18th February 2021

Your ref: 2020 94307 – Planning application, 1 Chadwick Crescent WF13 2JF. Erection of two storey side and rear extension and single storey front extension.

**PROPOSED SIDE ELEVATION**  
Scale 1:100@A1

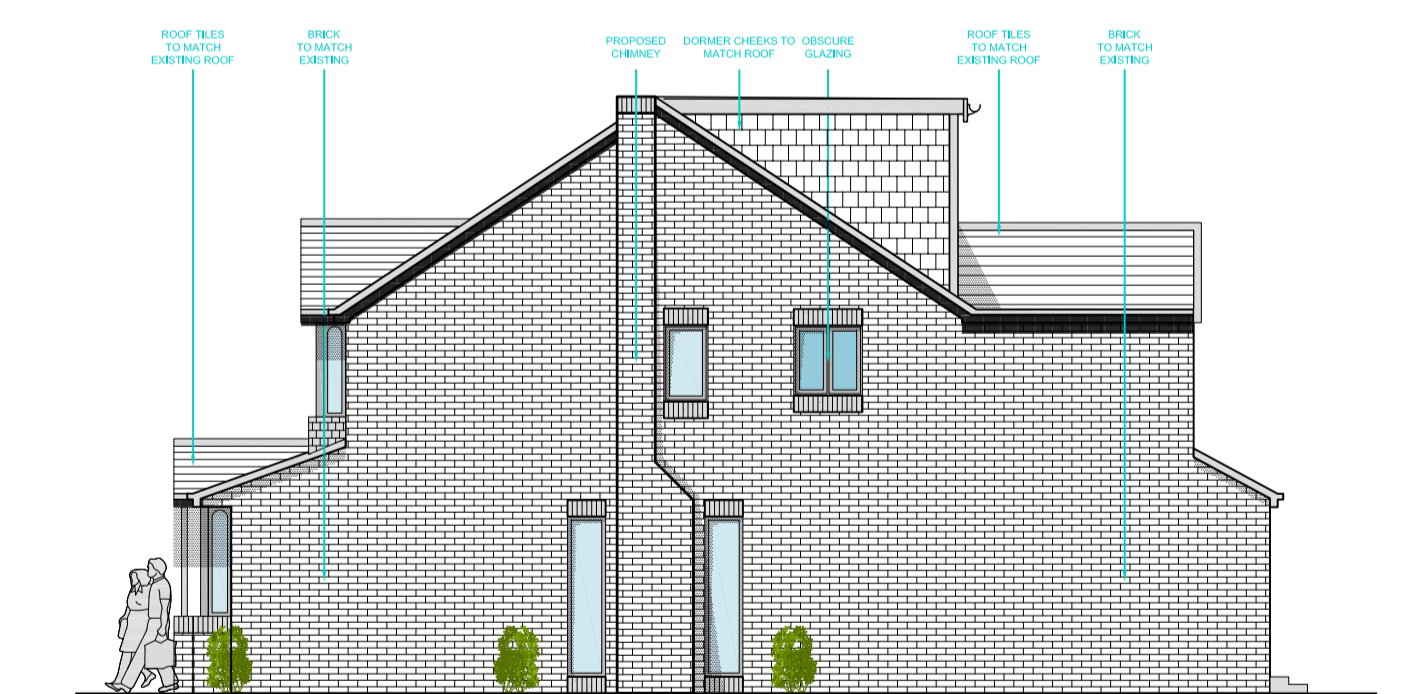
There would be significant loss of daylight to a primary ground floor room windows as well as the external areas of 15 infirmary road. The entire side extension would result in an unacceptable level of overlooking and loss of privacy given the number of windows and sheer scale of the proposal especially when considered with the raised height of 15 Infirmary Road.

The height of the proposed development with particular regard to the side and rear elevations would create extreme overbearing, overshadowing and would result in a visually intrusive impact. In part this would be due to the close proximity of the dwelling buildings. Specifically, this exacerbates the adverse impact resulting from the proposals over dominance and overbearing which would be more profound once the kitchen is extended as intended.

**PROPOSED SITE PLAN**  
Scale 1:500@A1

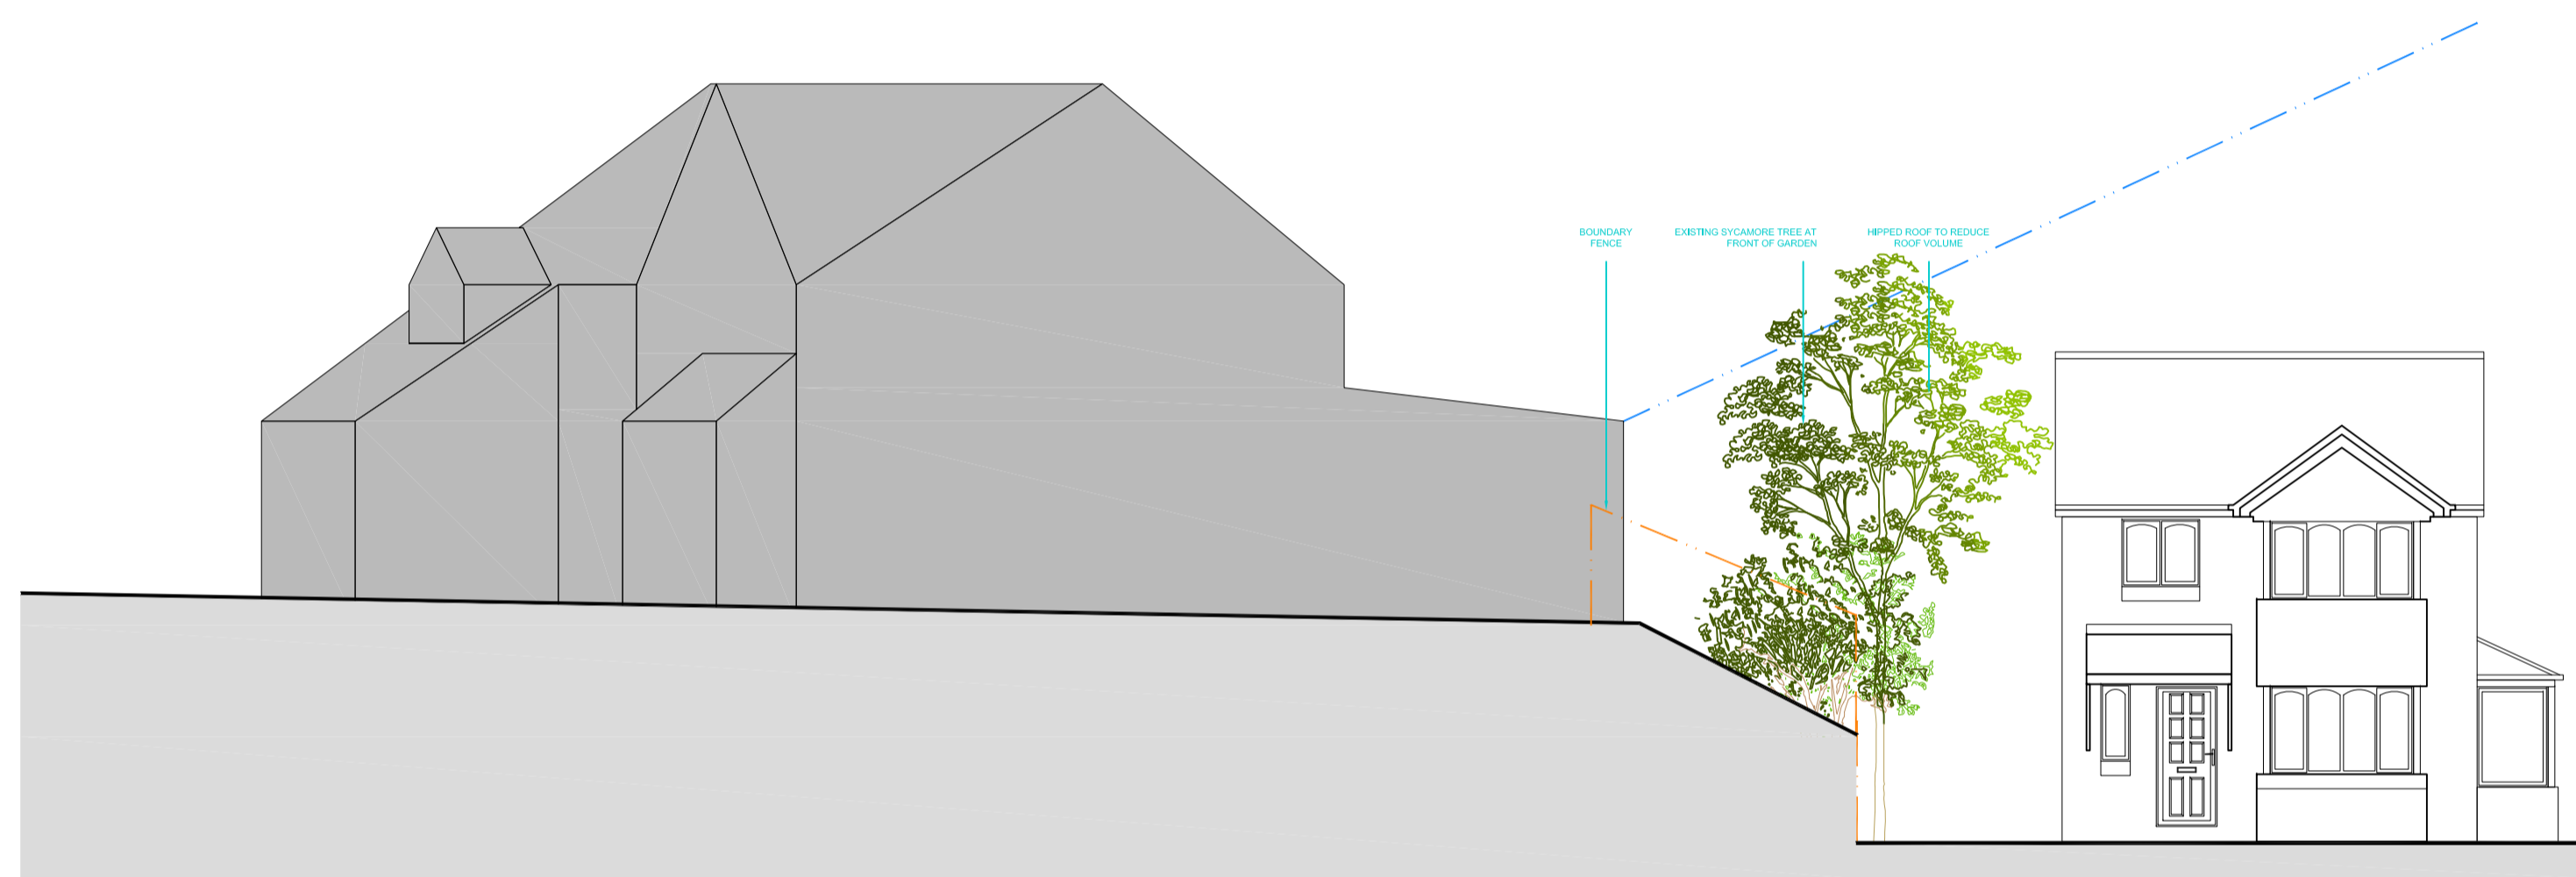
It is apparent from examination of the title deeds in respect of 1 Chadwick Crescent that the boundary line of the property runs in a straight line from the end of the garden, along the garage wall where it then meets the pavement. It is therefore highly unlikely that the property could be extended on the side, as proposed, to 3 meters without encroaching on the land of 15 Infirmary Road the neighbouring property given the stone wall lies firmly within the boundary of 15 Infirmary Road. As such there are legitimate concerns that the plans submitted are not accurate in depicting the boundary line of the existing site.

Moreover, the proposed extension would result in the overdevelopment of the site which inevitably would be harmful to the character and appearance of the area as well as the setting of 15 Infirmary road. It would almost eradicate the garden of 1 Chadwick crescent. To permit the development would be contrary to policies PLP 24 (a) (as modified) and PLP 35 (as modified) of the Kirklees Local Plan, as well as the aims of Chapter 12 of the National Planning Policy Framework, which seeks to achieve “good design”. Furthermore PLP, 24 (as modified) requires all new development to respect the scale height and design of adjoining buildings/properties, which this proposal simply fails to do.

The proposed 14 meter side extension would abut almost entirely with the existing detached single garage, as shown on the submitted plan. To grant the application would inevitably result in the occupants of 15 Infirmary road having to look directly onto 20 meters of brick walling in length, the majority of which is proposed as a double story structure. At a distance of less than a few centimetres from the garden and at most several meters from habitable room windows. This would decimate the visual amenity currently afforded to the occupiers of 15 Infirmary road and other neighbouring properties.
